Waterloo Metro Quarter Over Station Development Stage 2 - Southern Precinct (SSD-10437) - Notice of Exhibition

Thank you for your correspondence via the Major Projects Portal on 4 November 2020, requesting Transport for NSW (TfNSW) to review and comment on the above.

### 16.4 Appendix 4 - Collection Vehicle Swept Paths

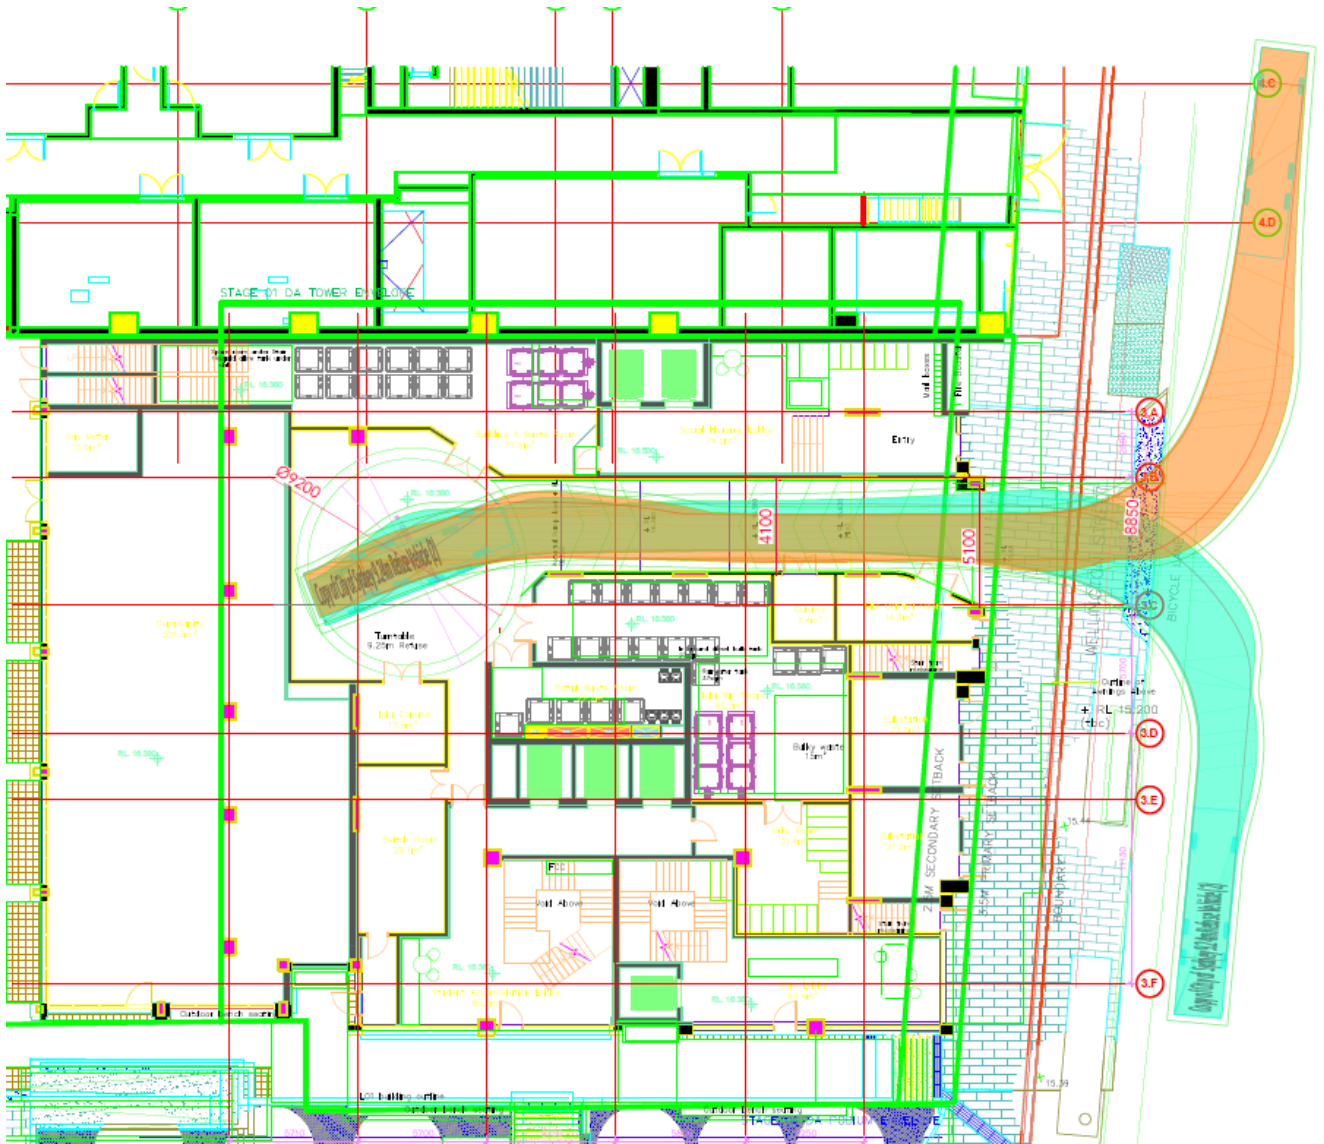
It is requested that the applicant undertakes a Stage 2 (Concept Plan) Road Safety Audit as part of the applicant's Response to Submissions for the proposed access arrangement to the loading dock in accordance with *Austrroads Guide to Road Safety Part 6: Managing Road Safety Audits and Austrroads Guide to Road Safety Part 6A: Implementing Road Safety Audits* by an independent TfNSW accredited road safety auditor.

- The single dock facility is unlikely to be sufficient to service the Southern Precinct, which is to accommodate more than 500 units with 435 student accommodation units. At the beginning and end of trimesters/semesters of the universities, it is likely that there would be movement of student residents of this developments. As a result, there would be demand for servicing activities (such as removalist and the like) during this period; and

Based on the results of the road safety audit, the applicant shall review the design drawings and implement safety measures in consultation with TfNSW as required.

- The applicant provides further details in relation to the management of service bays for the whole of WMQ as part of the response to submissions; and
- The applicant be conditioned to update the Freight and Servicing Management Plan in consultation with TfNSW, prior to the issue of any Construction Certificate.
